TAMWORTH REGIONAL COUNCIL SUBMISSION – STATE SIGNIFICANT DEVELOPMENT – TANGARATTA FEED MILL (SSD-58801472)

I refer to your correspondence received 09th October 2024 regarding the public exhibition of a State Significant Development, being the Tangaratta Feed Mill (SSD-58801472). Please find Tamworth Regional Council's comments on the proposal below.

**MARK UP ONLY
NOT FOR CONSTRUCTION**

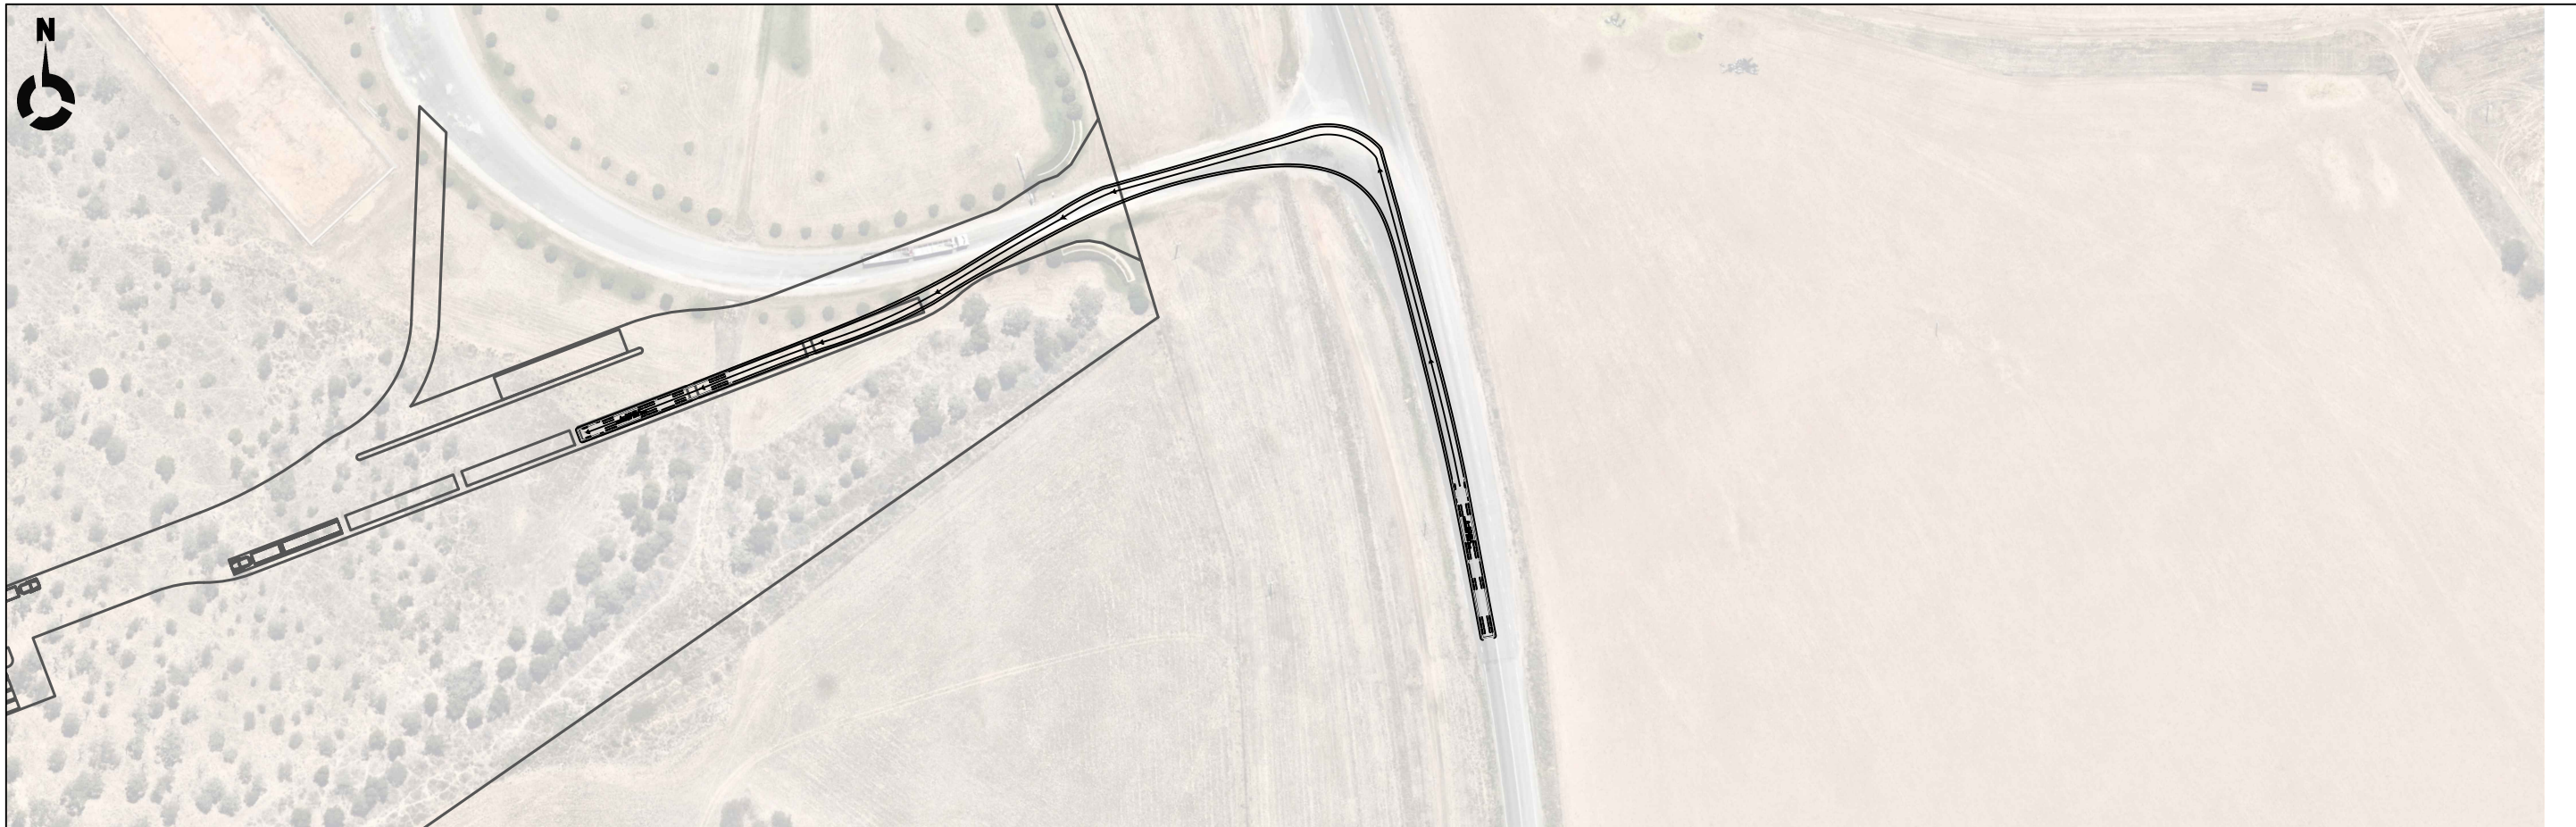
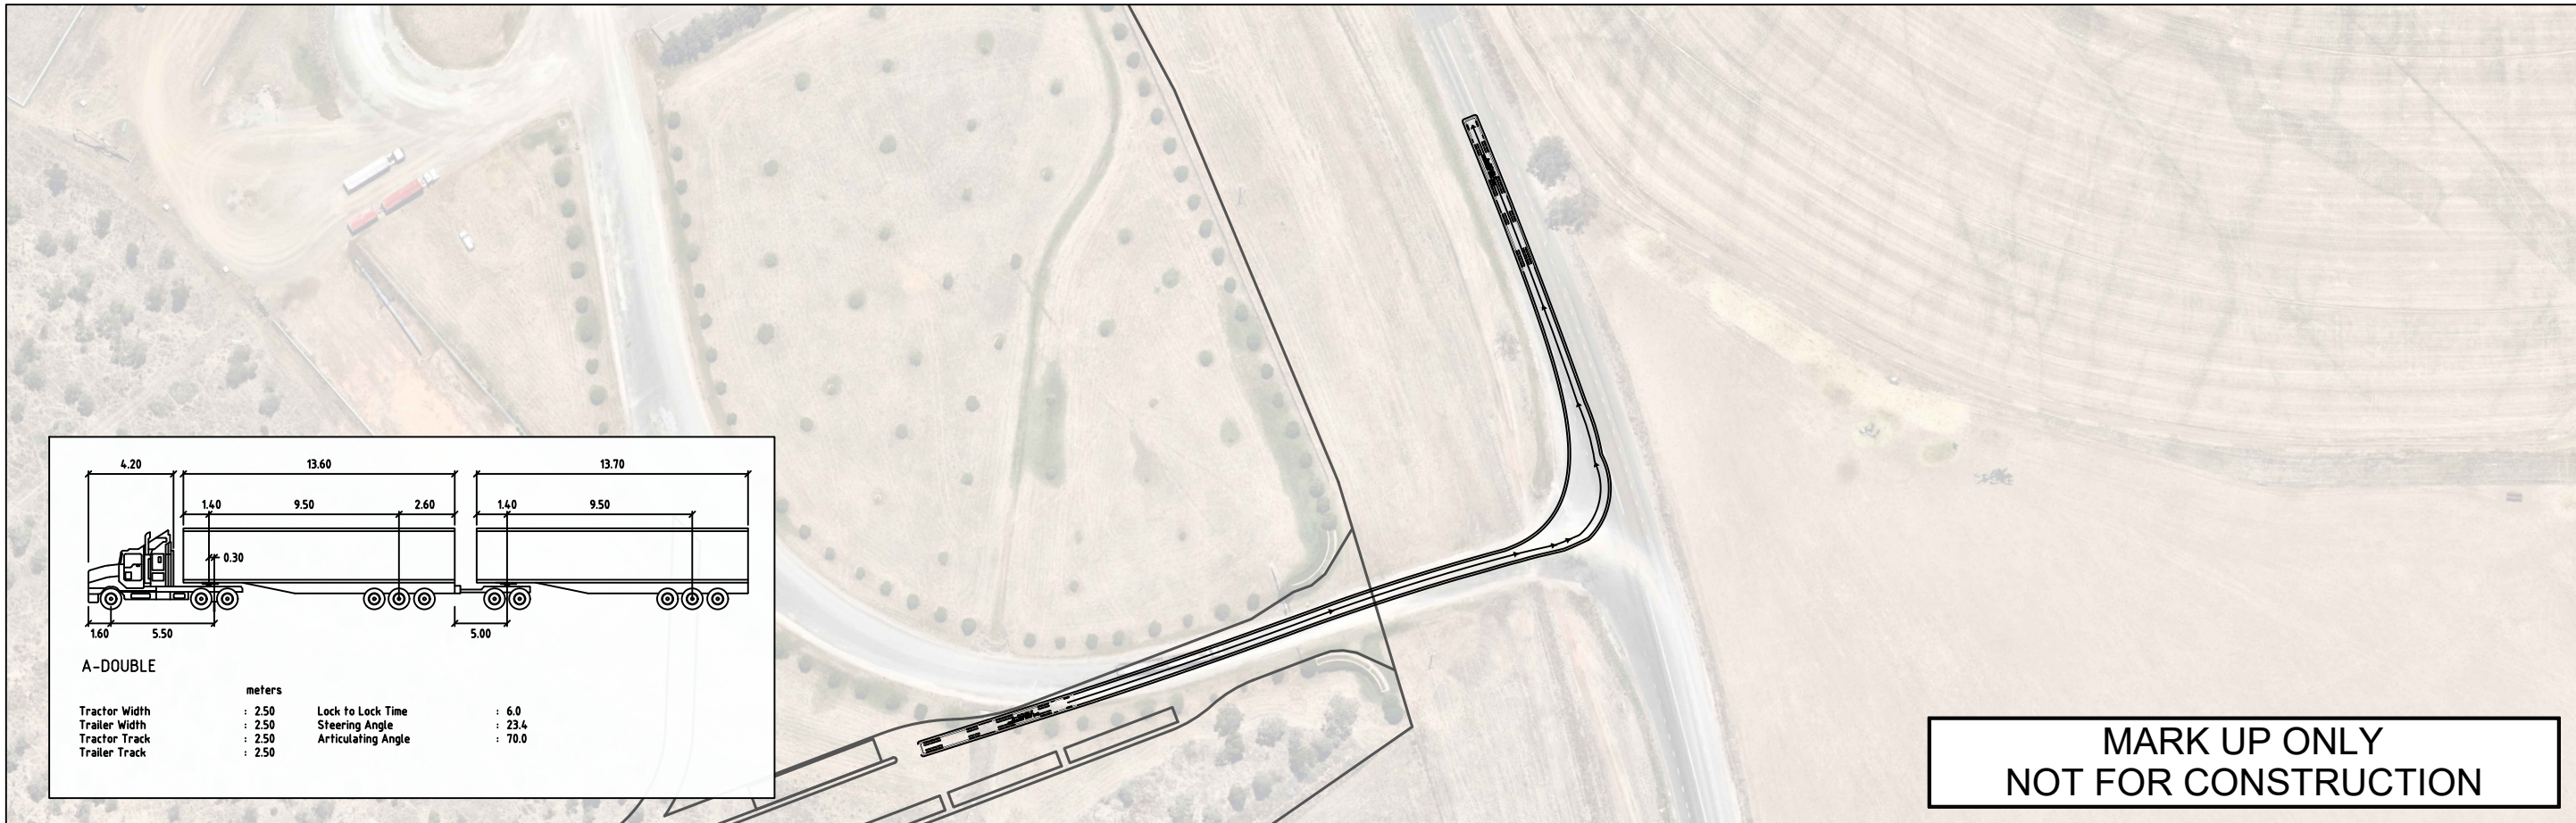
Council has reviewed the Traffic Impact Assessment (TIA) for the proposed development. Based on the review, it is identified that Wallamore Road is currently not gazetted for vehicles larger than a B-Double, while the Oxley Highway is approved for B-Triple and AB-Triple vehicles, and conditionally approved for A-Double vehicles. Should the applicant intend to access the site with vehicles larger than a B-Double, a route assessment must be prepared according to NHVR requirements for the "last mile" of the proposed transport route, specifically covering Bowlers Lane and Wallamore Road.

Deceleration and acceleration distances, along with BAL/BAR turn treatments, must be assessed for the largest intended vehicle at the site access and at relevant intersections along the transport route. Further, the site access should be designed to permit the largest vehicle to enter the site while an exiting vehicle holds before Wallamore Road.

Furthermore, the access must be widened with pavement of suitable depth to accommodate the swept path of the largest vehicle, and it should be sealed to ensure all-weather access and to prevent soil or loose gravel from being tracked onto Wallamore Road.
